Reference: TR010027 – M42 J6 Improvement
Bickenhill & Marston Green Parish Council (BMGPC): Responses on The Examining Authority's (ExA) draft Development Consent Order (dDCO) commentary schedule of changes (issued 8th November 2019)

15th November 2019

Drawing Title  
**FIGURE 8.3 PROPOSED LANDSCAPE PLANTING SHEET 1 OF 3**

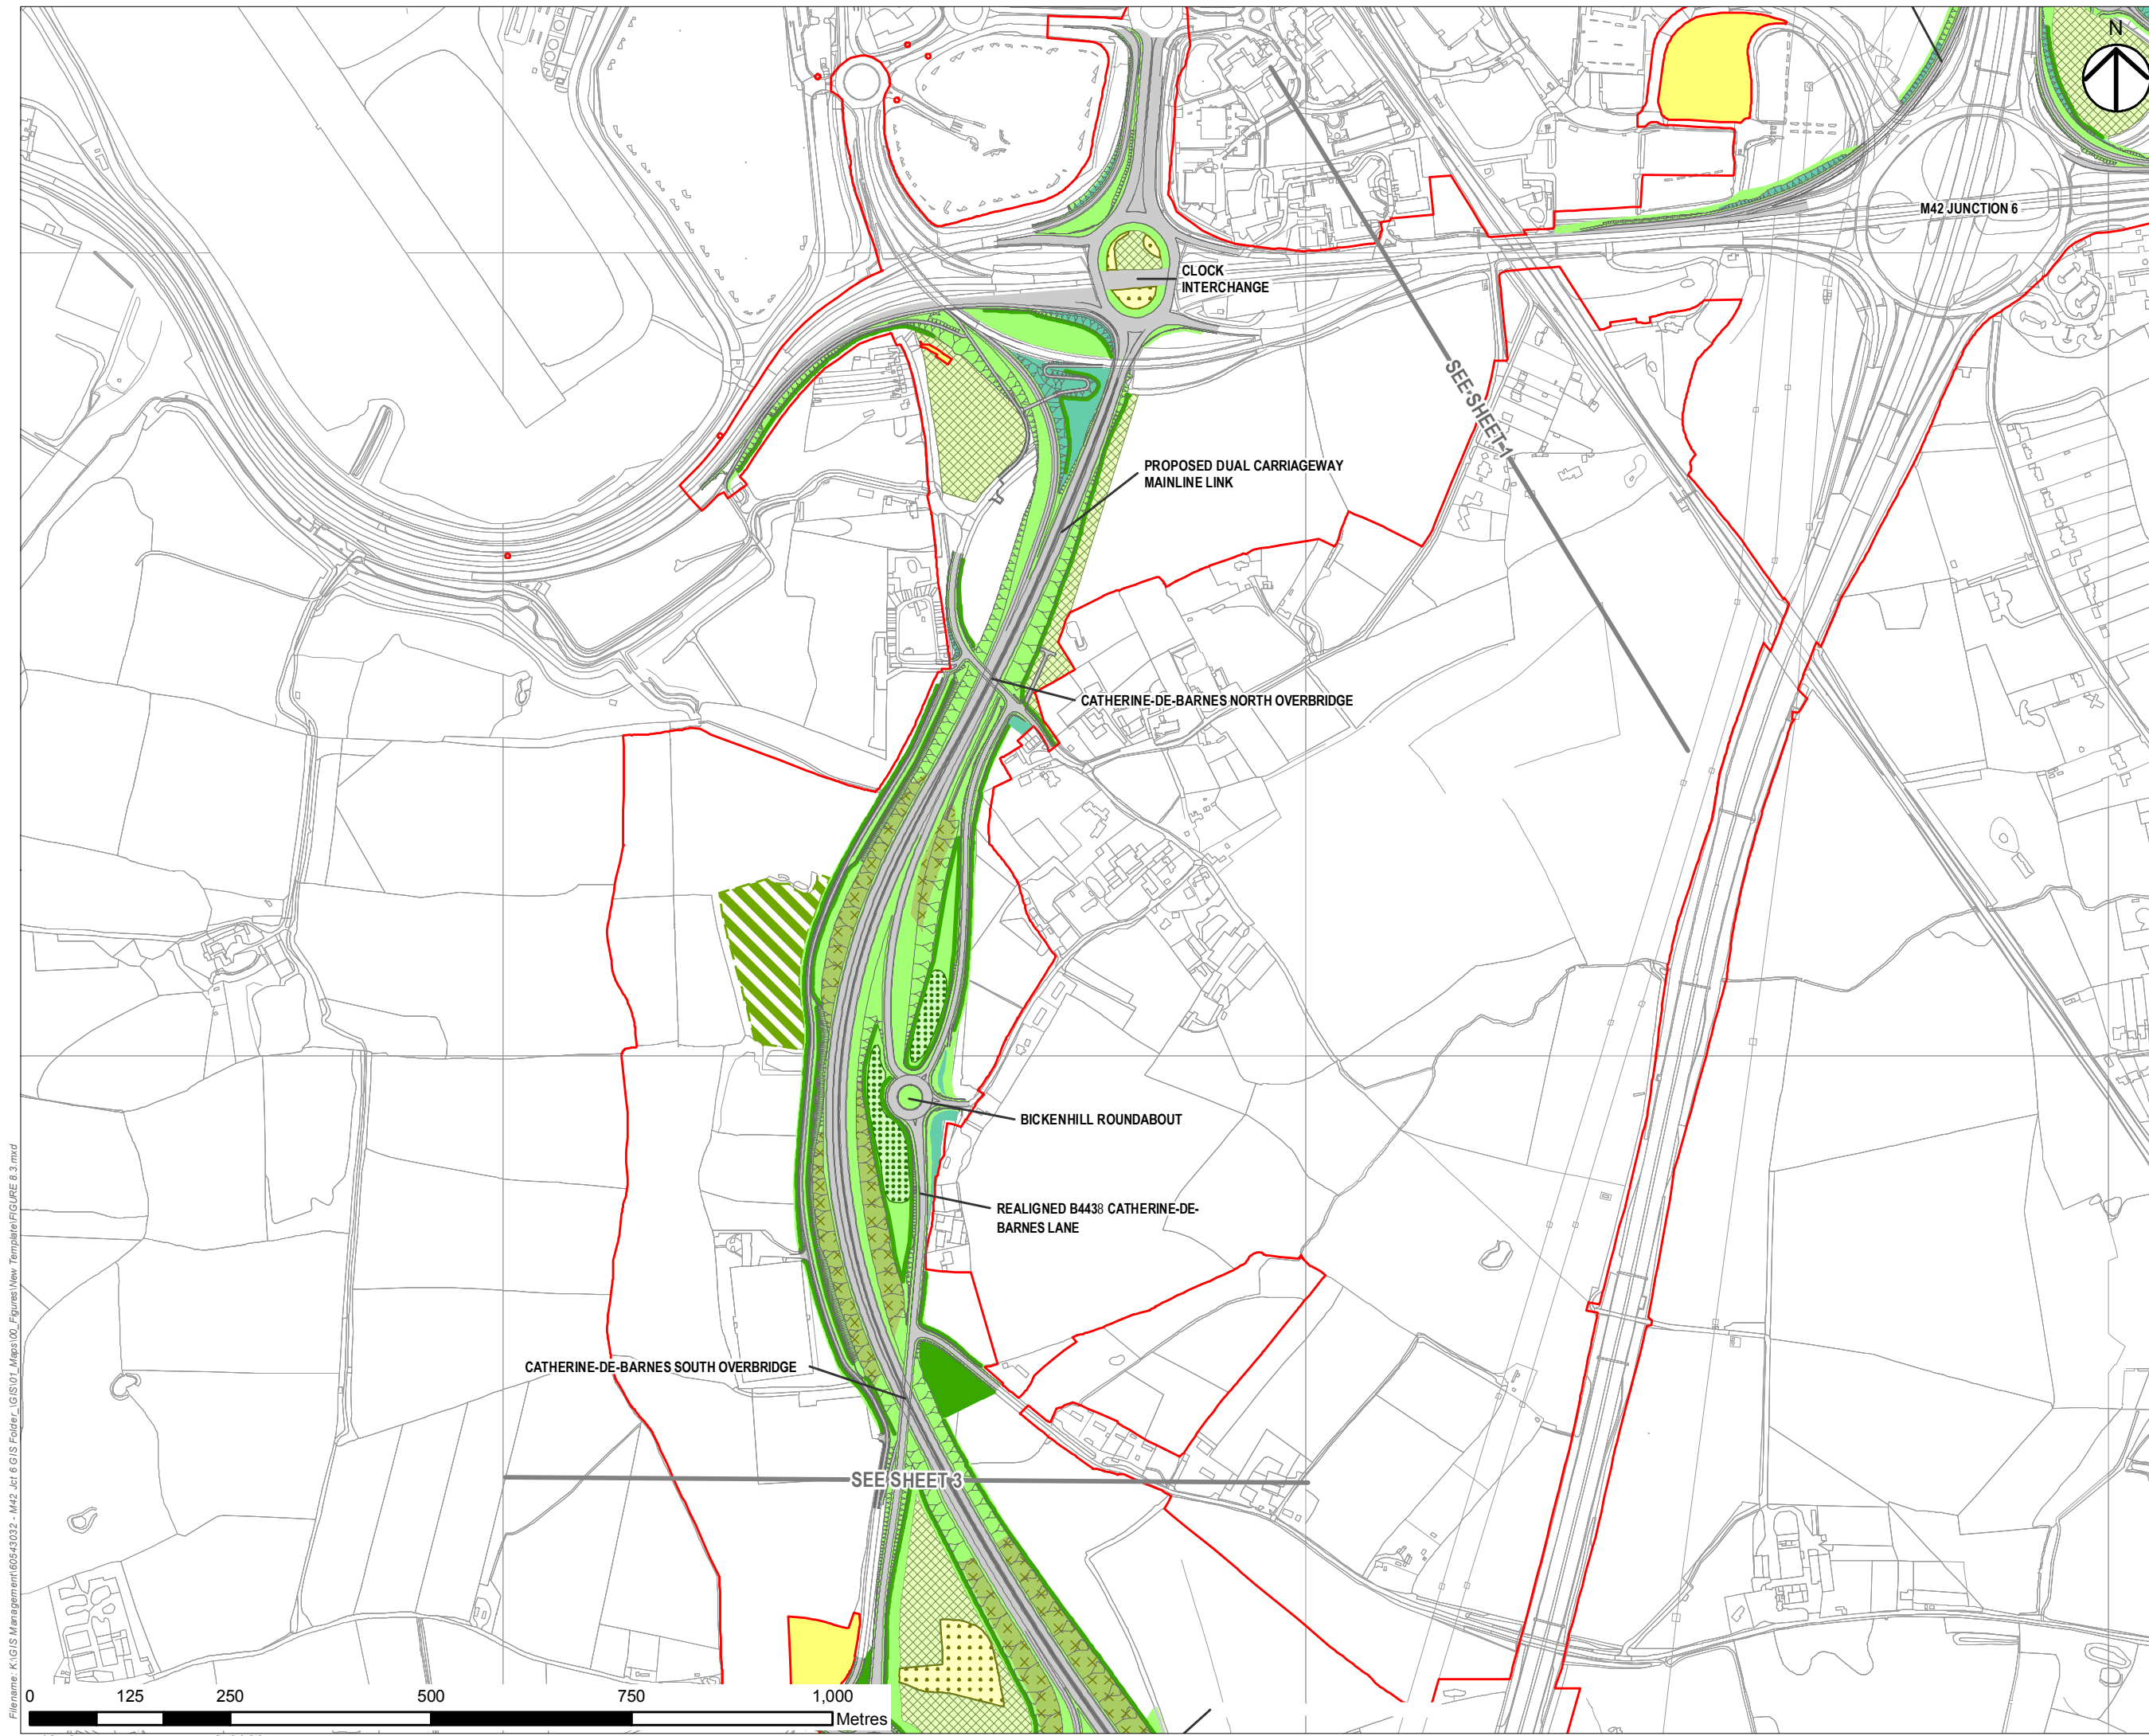
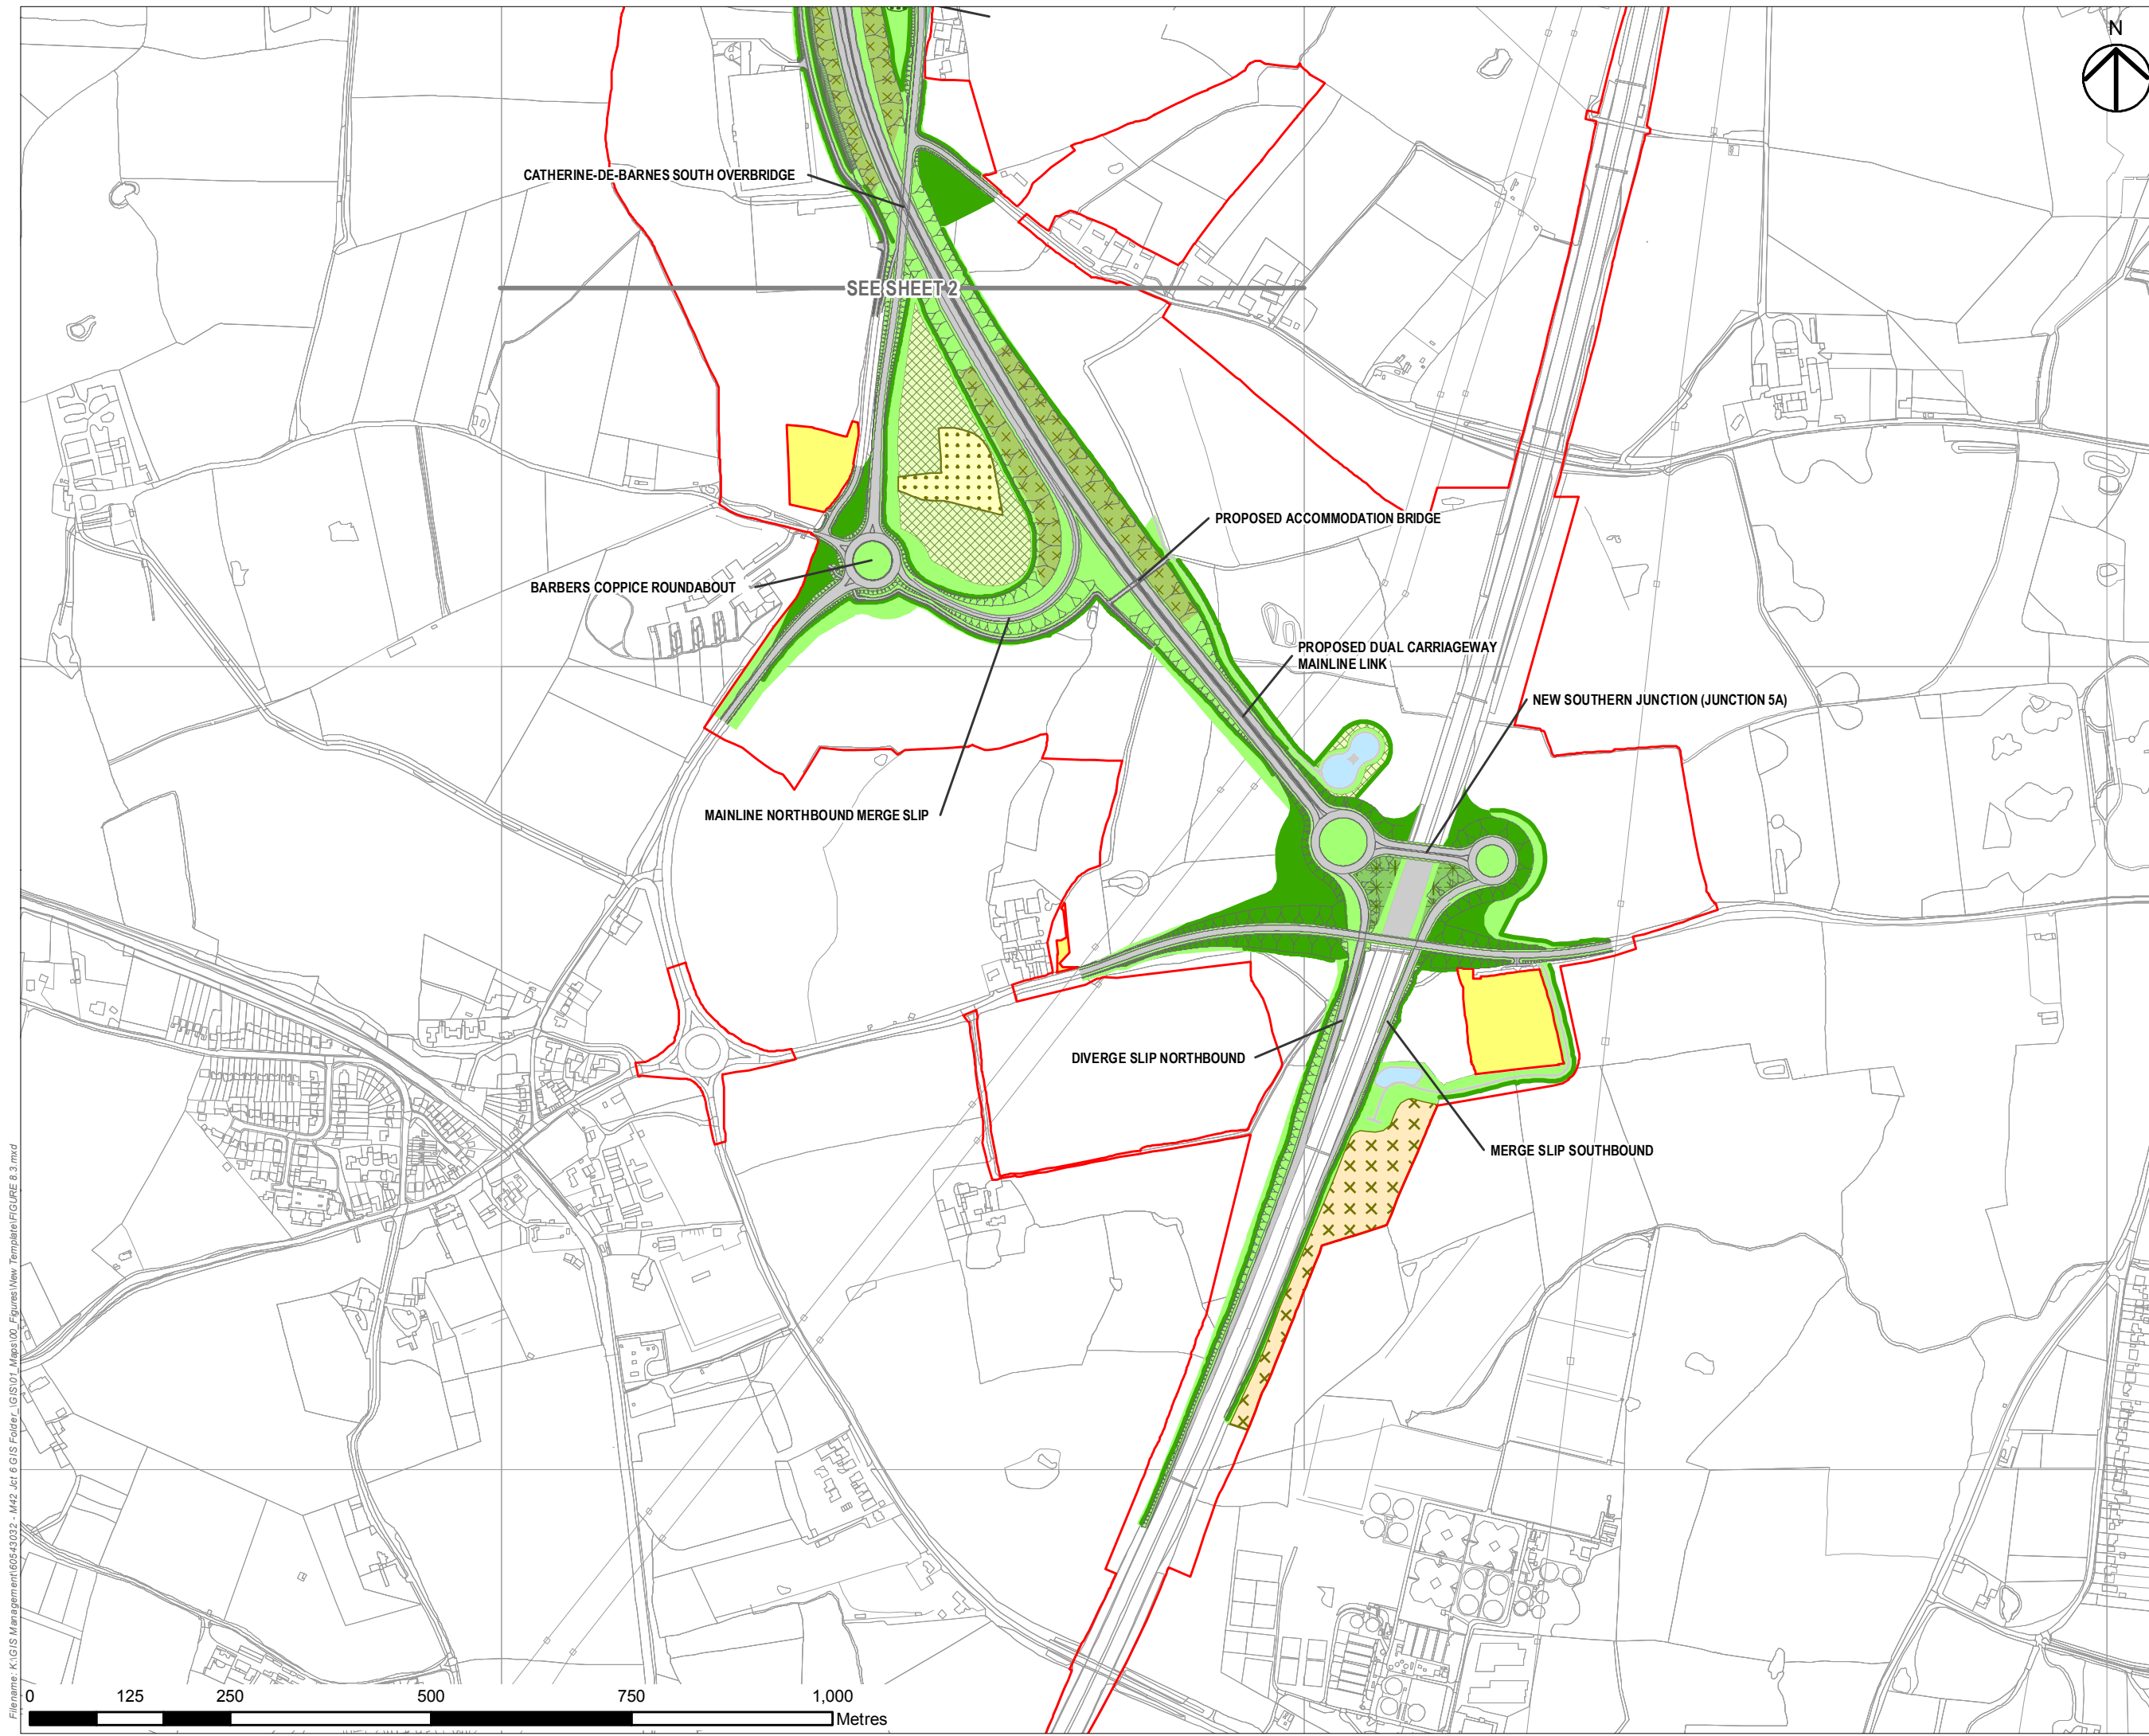
Landscaping: We have requested the opportunity for the Parish Council to comment on the landscaping plan of the scheme in the vicinity of the village. We understand that the REAC will be updated at Deadline 9 to reflect such a commitment. Subject to this inclusion we have no further comments on this matter.
